THE MICA PRE-APPLICATION MEETING

March 7, 2016

### Turning Path - Single Unit Delivery Truck Access

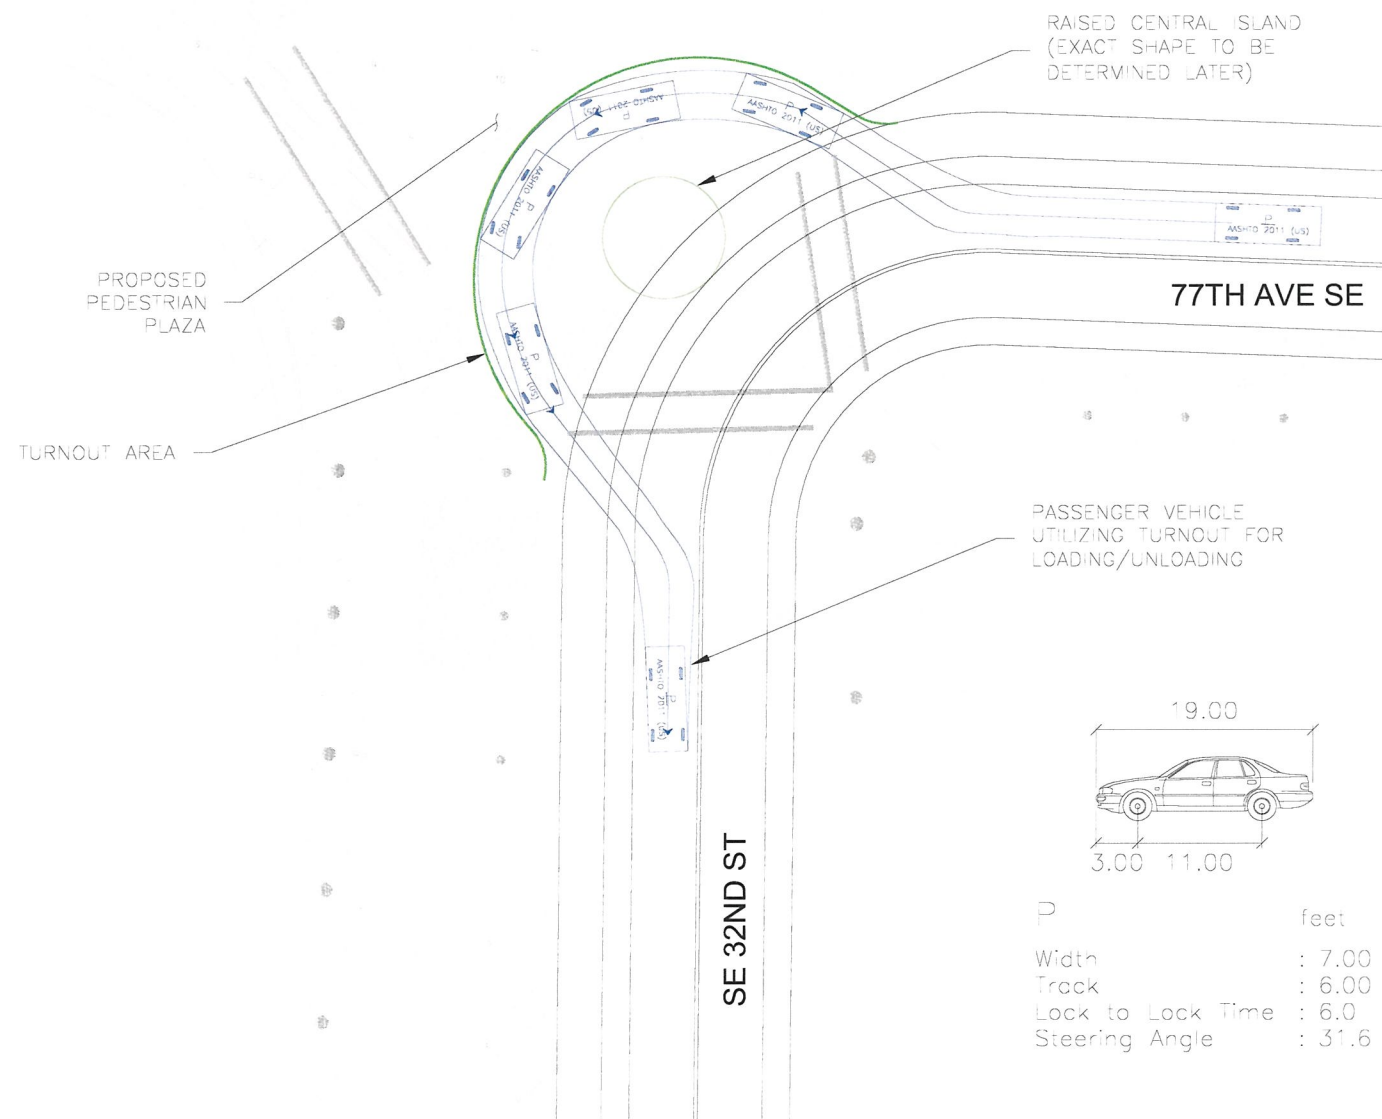
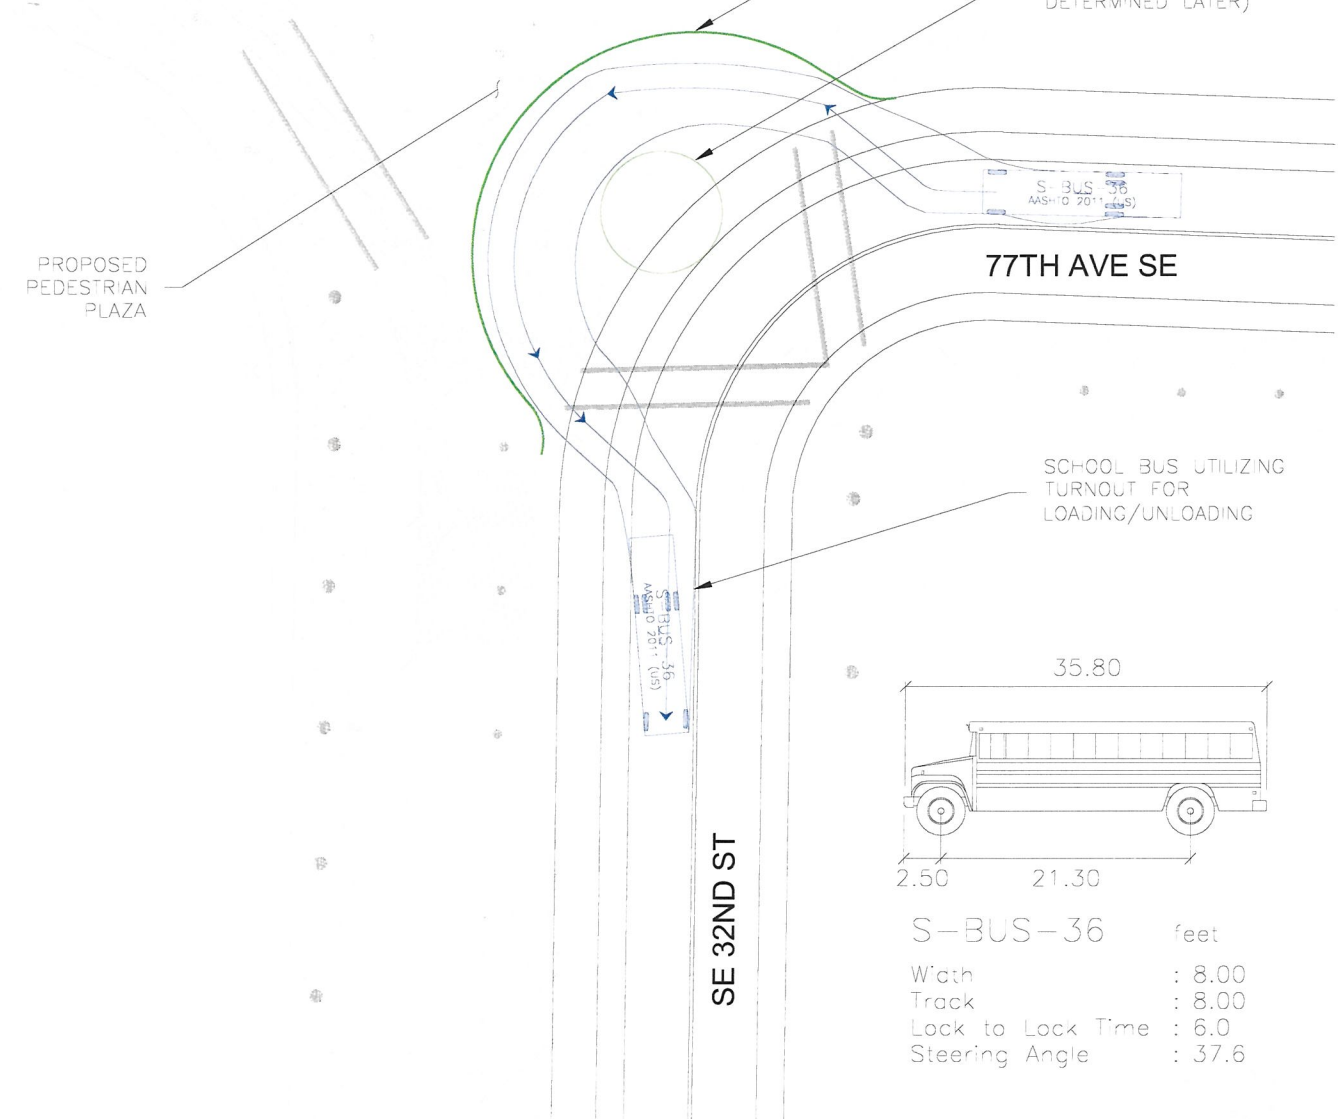
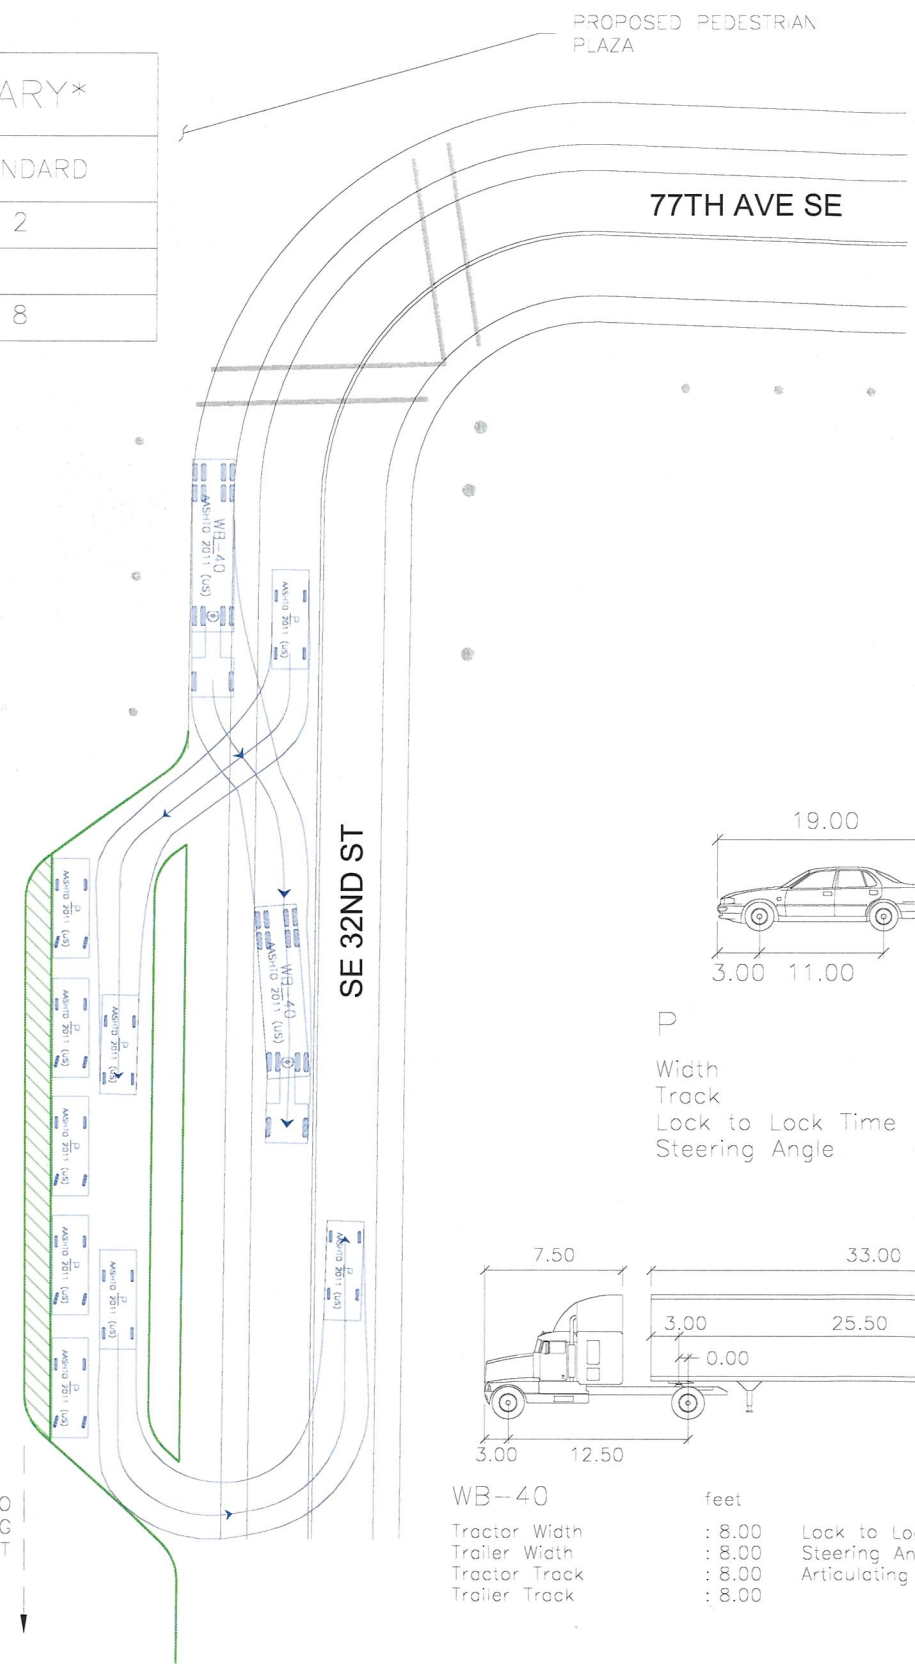
Attachment G to the Draft SEPA Environmental Checklist proposes parking that fails to acknowledge let alone comply with MICC 19.05.010(D) and MICC 19.05.020(B)(4).

By way of another example, when asked “how many additional parking spaces ... the completed project [would] have,” the Draft SEPA Environmental Checklist provides the following response: “There will be accessible parking available on SE 32nd Street.” See Exhibit 4, page 17, at Section B(14)(d). This response fails to acknowledge let alone address the requirements of MICC 19.05.010(D) and MICC 19.05.020(B)(4).

1. Attachment C – Hart Crowser “Geotechnical Engineering Design Report”
2. Attachment D – Hart Crowser “Supplemental Memorandum”
3. Attachment E – “Wetland Delineation Report”
4. Attachment F – “Conceptual Mitigation Plan.”
5. Attachment G – “Parking and Access Sketch”
